MECKLENBURG COUNTY
Park and Recreation Department

MEMORANDUM

RE: Rezoning Petition #2023-046
PID# 22916101, 05, 03, 84

SCHEMATIC SITE PLAN

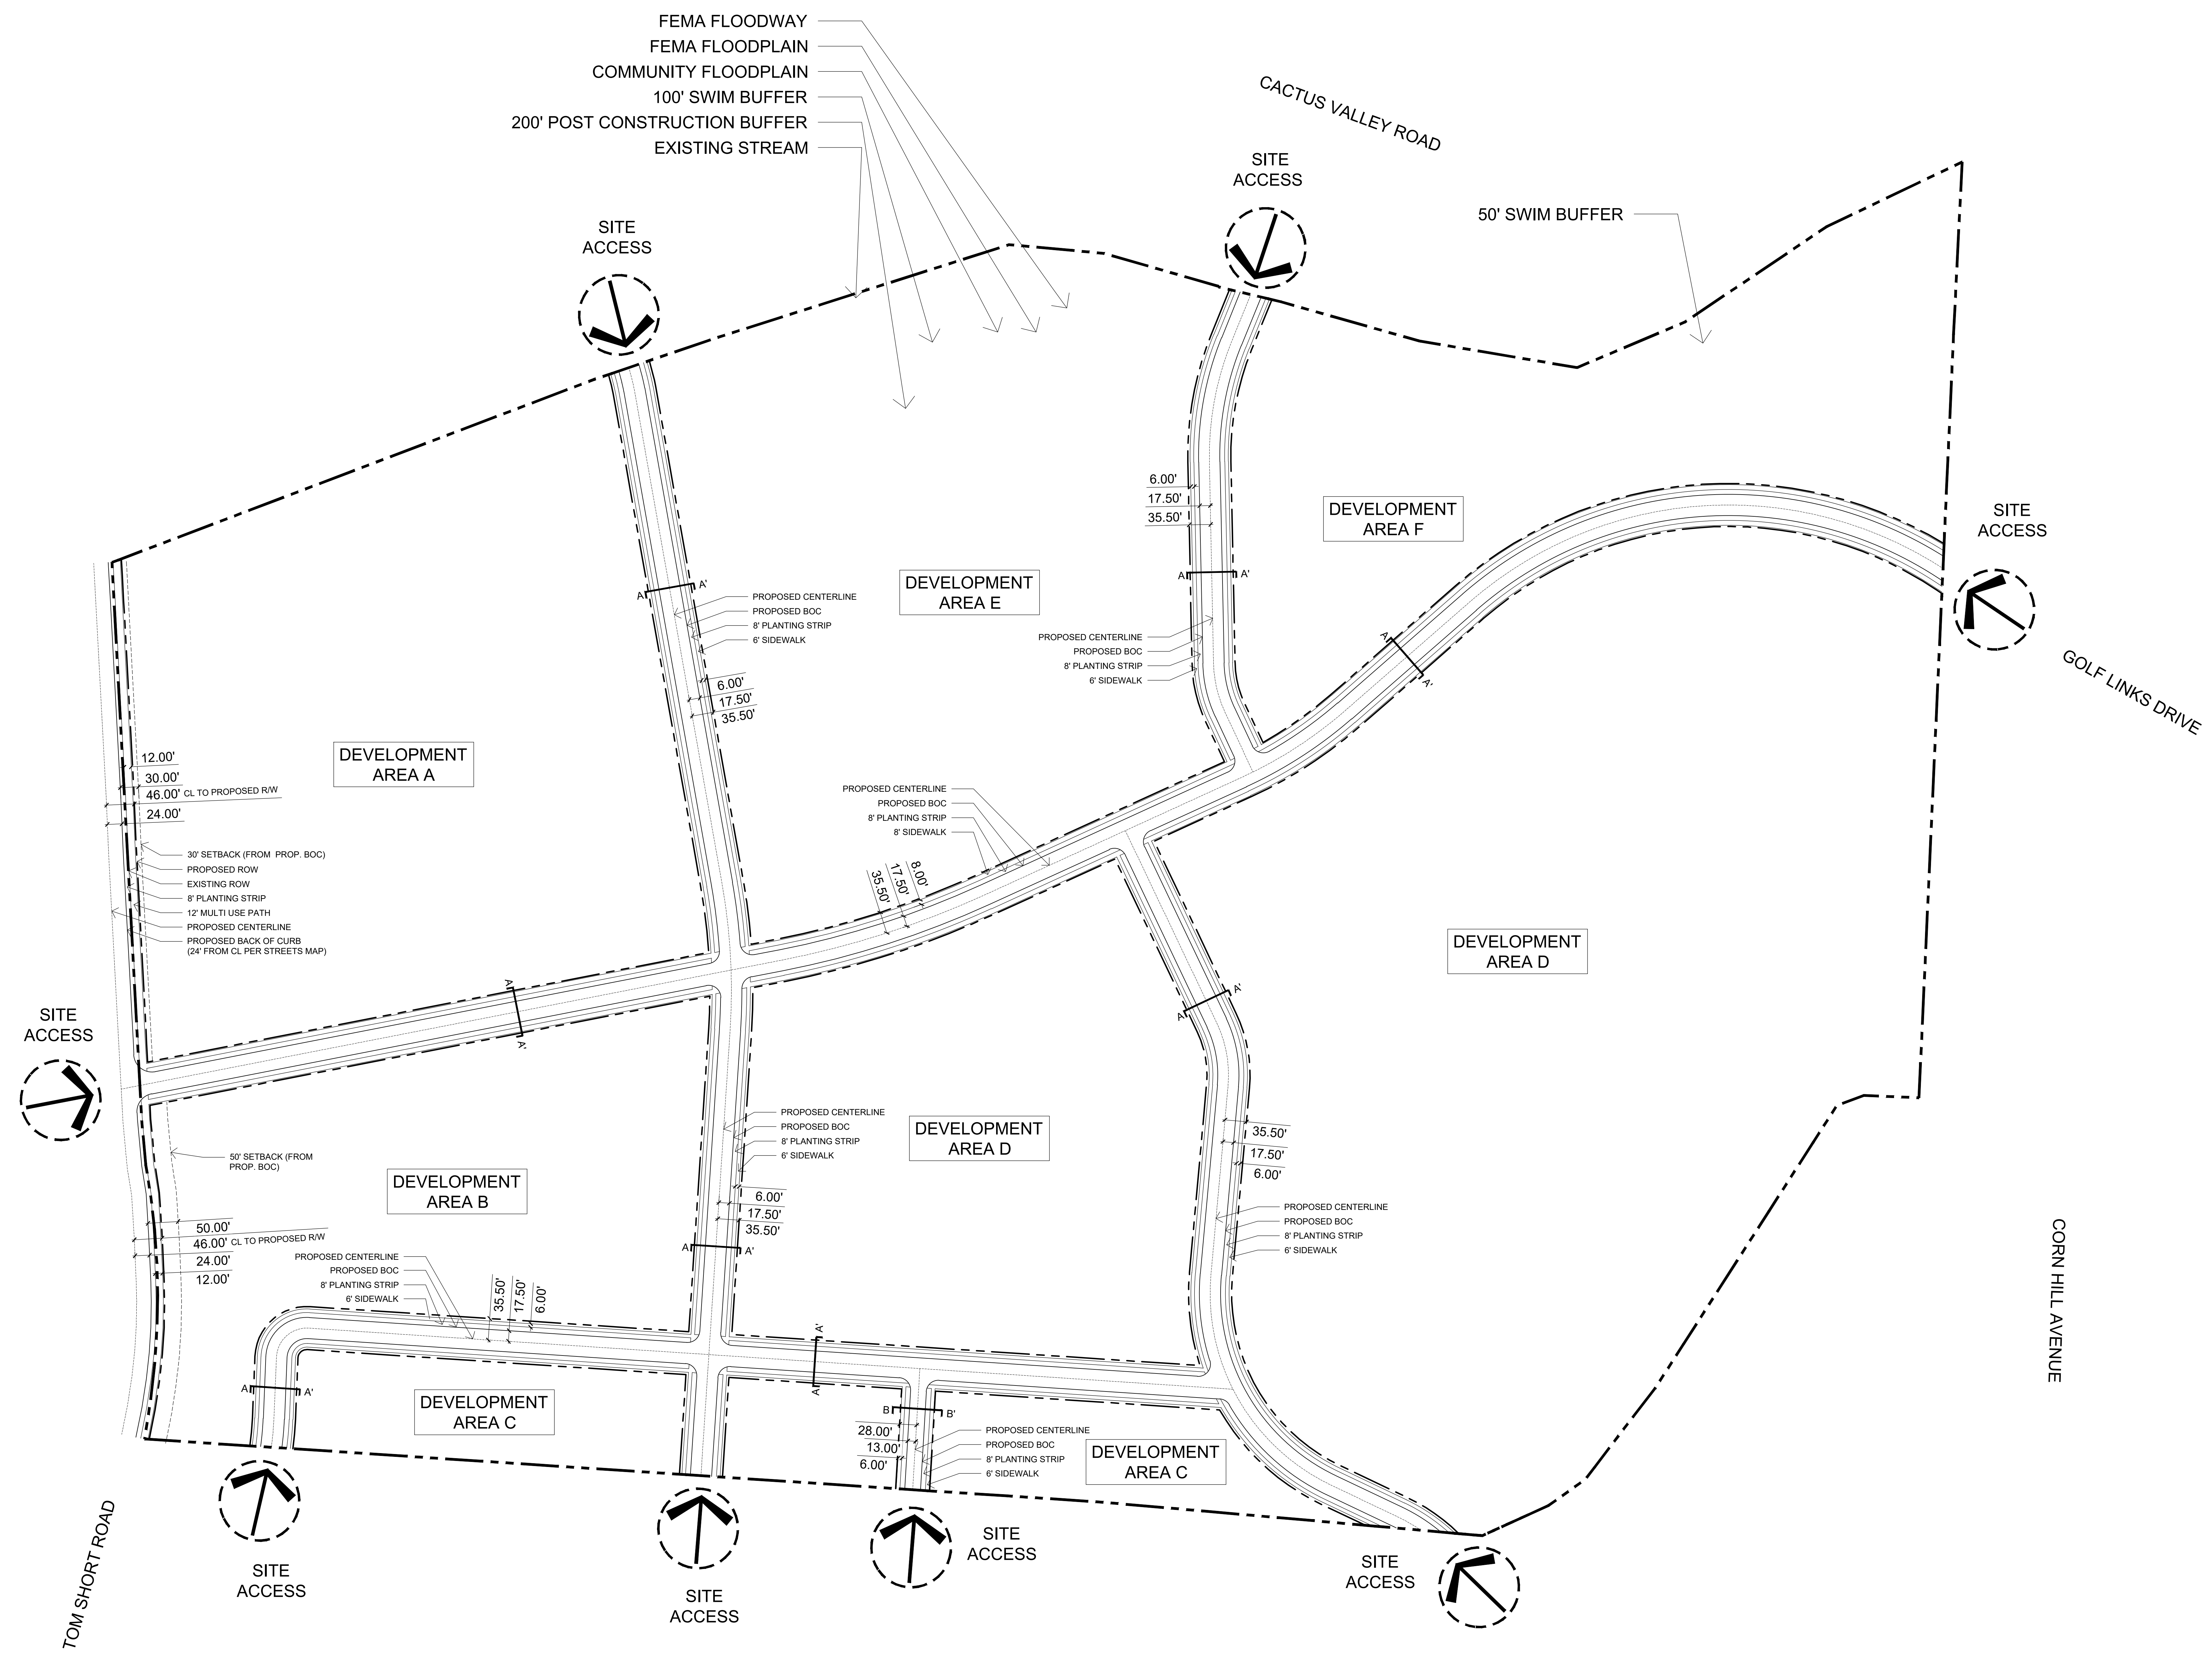
MCPR requests minimum of **2.0** acres to be dedicated and conveyed to Mecklenburg County for a future local park on the East side of the development. This requested park land shall be adjacent to a public right-of-way for access and is conducive for the development of the typical amenities found in a local park and cannot include tree save parcels or stormwater BMP's.

Additionally, MCPR requests the dedication and conveyance of the 100' SWIM or a minimum of a 100' width easement along Flat Branch to Mecklenburg County as permanent greenway easement. Greenway easements may overlap tree-save. Greenway easements and parkland dedication shall be conveyed by the first CO.
